Application Ref:	2026/0352			 Ribble Valley Borough Council www.ribblevalley.gov.uk
Date Inspected:	04/08/2026	Site Notice:	N/A	
Officer:	EP			
DELEGATED ITEM FILE REPORT:				
				APPROVAL

Development Description:	Proposed dormer extension to both side elevations.
Site Address/Location:	34 Fountains Avenue Simonstone Burnley BB12 7PY.

PROPOSED FIRST FLOOR PLAN
SCALE - 1:50 @ A1

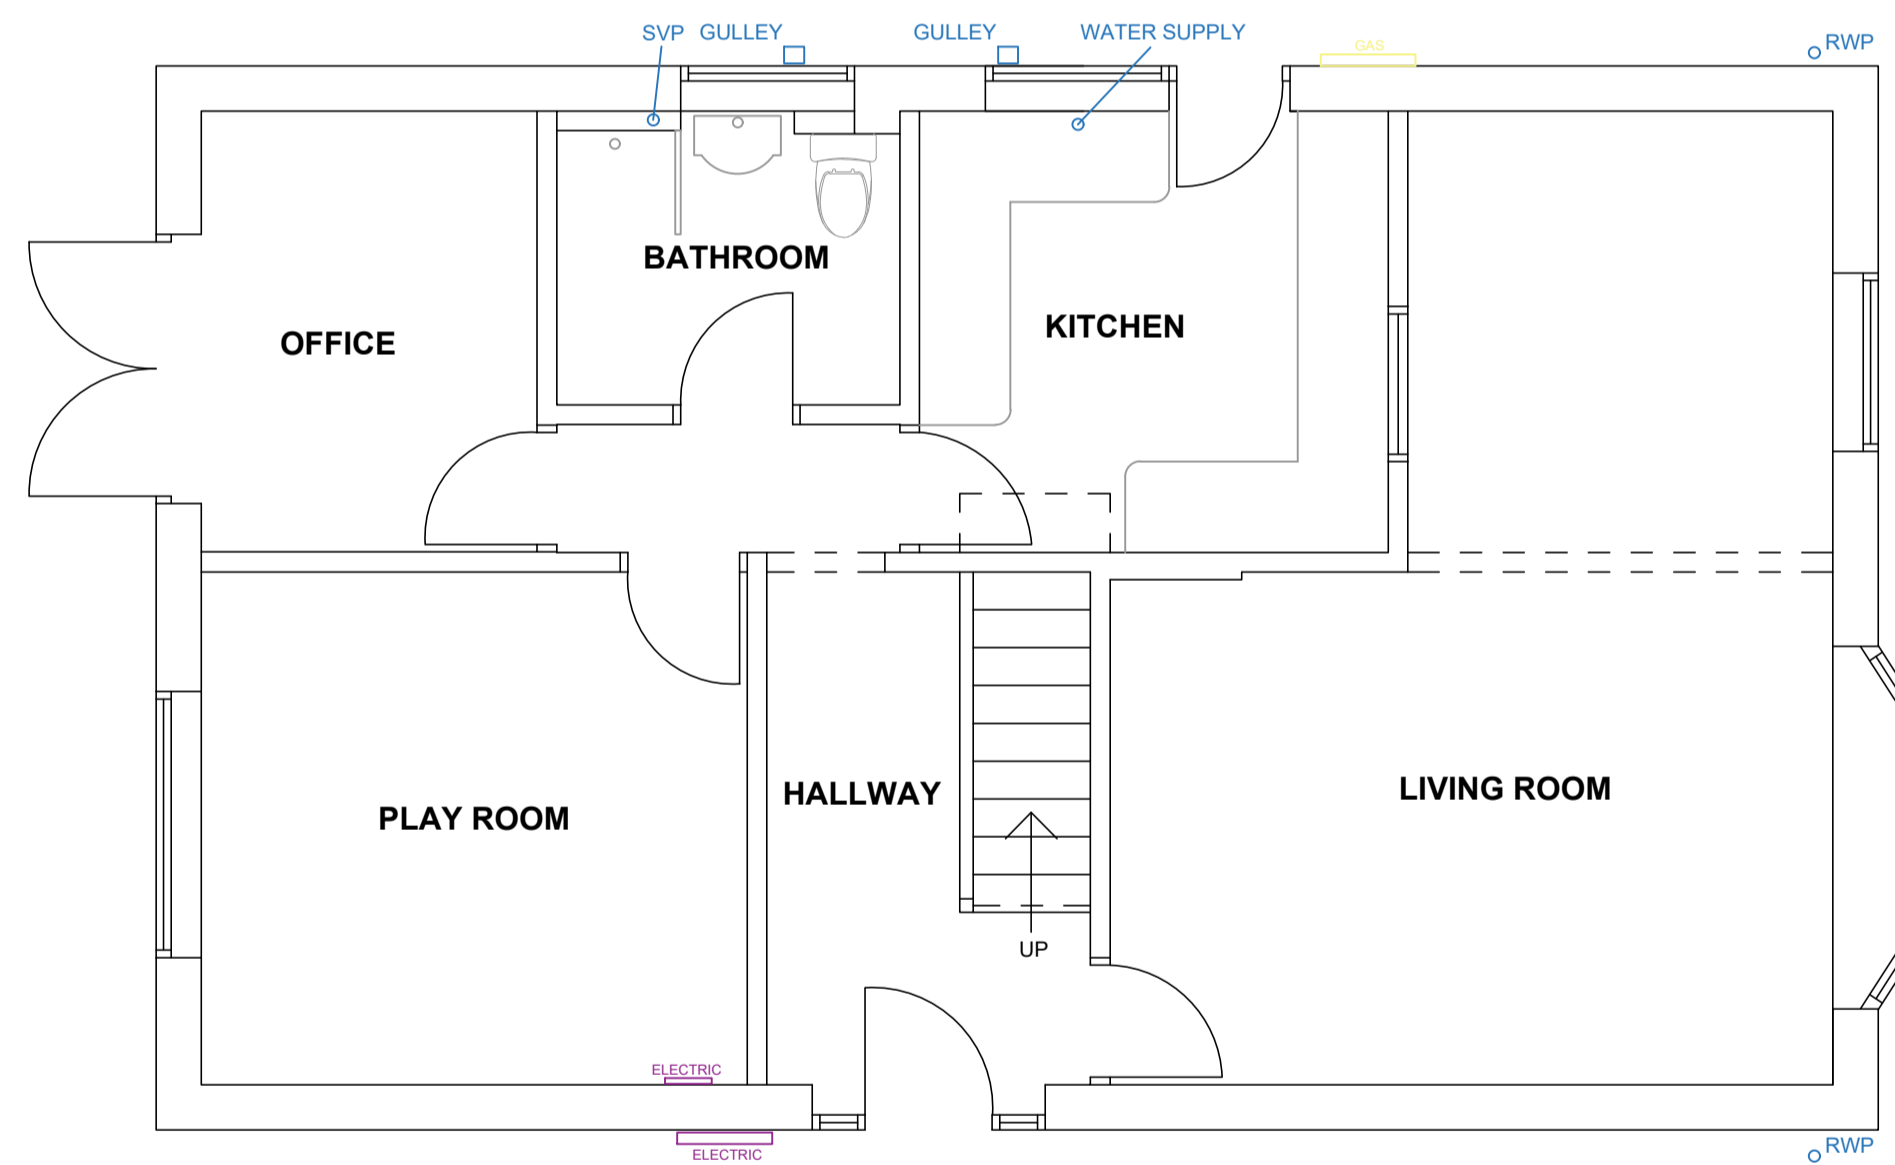
The proposed dormer extensions will benefit from new window openings facing neighbouring properties. The eastern side of the existing roof slope benefits from a much smaller dormer extension featuring one window opening which serves a bathroom. The proposed dormer to the eastern side elevation is much larger, but due to the orientation of the existing dwelling won't result in any loss of light or overshadowing. The eastern dormer has two windows openings proposed, one is in an identical position to the existing bathroom window. The second is positioned further north and therefore creates new opportunity for overlooking into neighbouring private amenity space. It is recognised that there is similar arrangement to this found on neighbouring properties, but this would not justify harm to residential amenity. To mitigate this harm, the proposed window openings would need to be obscurely glazed which can be achieved via planning condition.

PROPOSED SIDE ELEVATION
SCALE - 1:50 @ A1

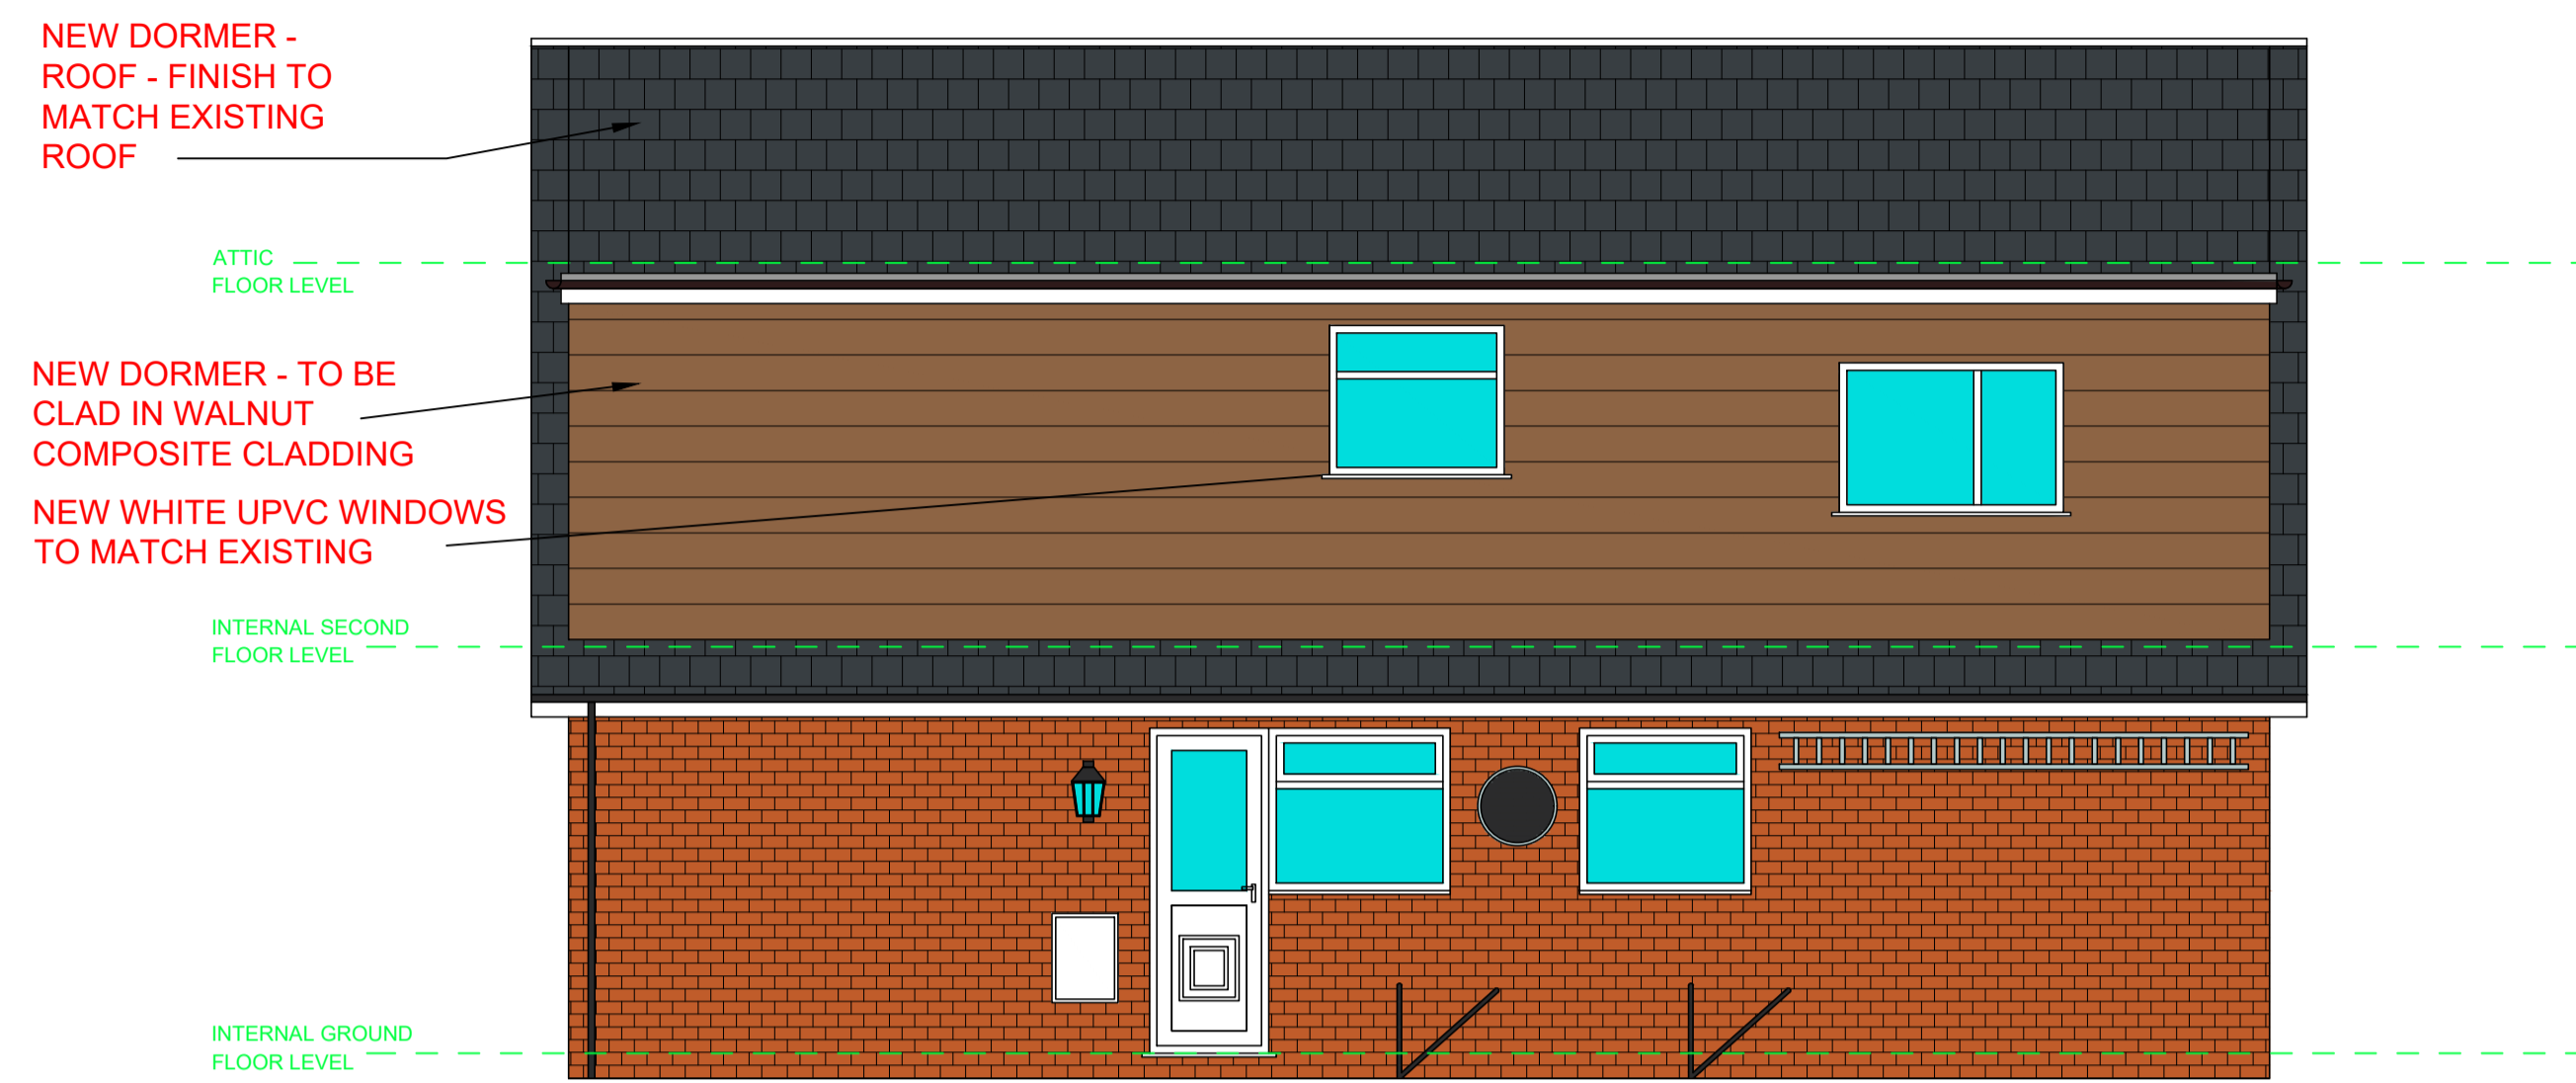
Similarly, the proposed dormer to the western side of the roof slope has two window openings proposed. However, due to the orientation of the application dwelling and the neighbouring dwelling within their plots, the dormer windows will provide views solely of the front curtilage of the neighbour to the west. Given the open nature of the front boundary, this front curtilage is not considered private, and the views afforded from the proposed windows would be similar to that already afforded from within the public realm. Therefore, no adverse impact is expected in this respect to warrant refusal or to require further mitigation.

The proposed dormer extensions will be readily visible from within the public realm, and as such consideration must be given into the impact on the visual amenities of the area. The proposed dormers will be constructed so that they meet the ridge line of the existing roof and occupy the majority of the roof slope. Whilst the dormer extension would be a visually prominent addition to the dwelling, there are dormers of the same style found in the vicinity, as such it is not considered they would look out of character.

In respect of materials, the proposal will consist composite cladding to the elevations with uPVC windows, all of which match the existing dwelling. There are varying types and colours of cladding found in the vicinity and therefore, it is considered that the proposal will integrate sufficiently into the street scene.
